From: Sarah Fletcher <fletchsa1@gmail.com>
Sent: Saturday, February 11, 2023 12:52 PM
To: Kate Akyuz
Cc: Jessi Bon; Andrew Leon; Alison Van Gorp; Council; Planning Commission; Design Commission
Subject: Re: Question on the Baskin Robbins Project
Attachments: Baskin Robbins Green Roof Sedum trays 24 inches.pdf

Thank you for commenting on the proposal to construct a 10-unit apartment building at 2900 78th Ave SE, as processed under permit number DSR22-014. You have been added as a party of record for this permit.

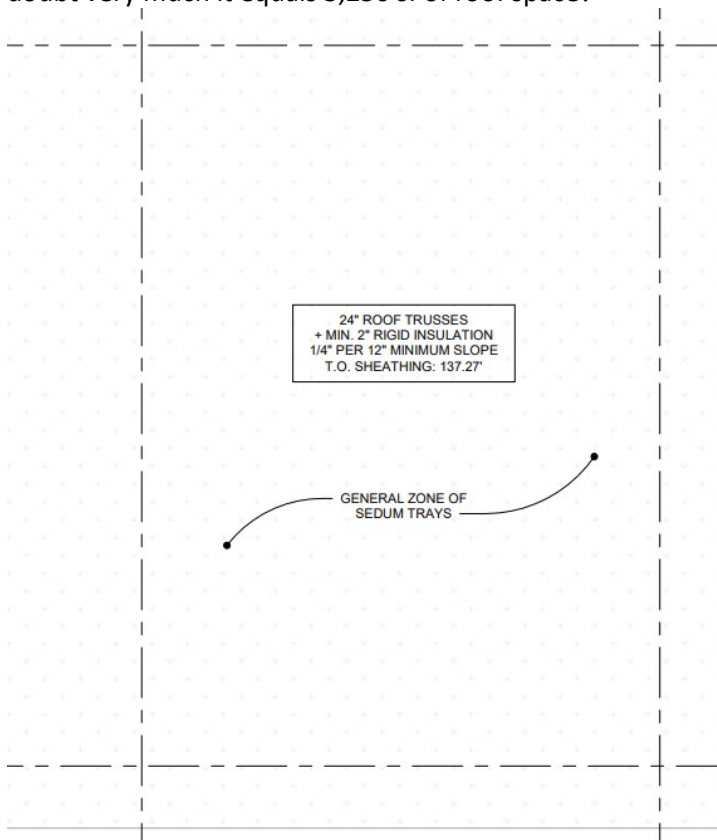
I am sorry, but did you not look at their plans? See attached (page 7). They plan on putting 24 inches worth of sorghum trays which you could buy at Home Depot and just shove them on the roof. They do not mention how they plan on securing the trays and there does not appear to be a plan L2.0.

It shows on page 13: "Green Roof Trays C/L2.0" so where is that L2.0 plan?

And I am sorry, but one heavy rain will just overflow onto the roof itself.

And if you look at the attachment, I am a layman so I have absolutely no idea how to read the plan. What does it tell you about how big a section are the trays going onto in the middle?
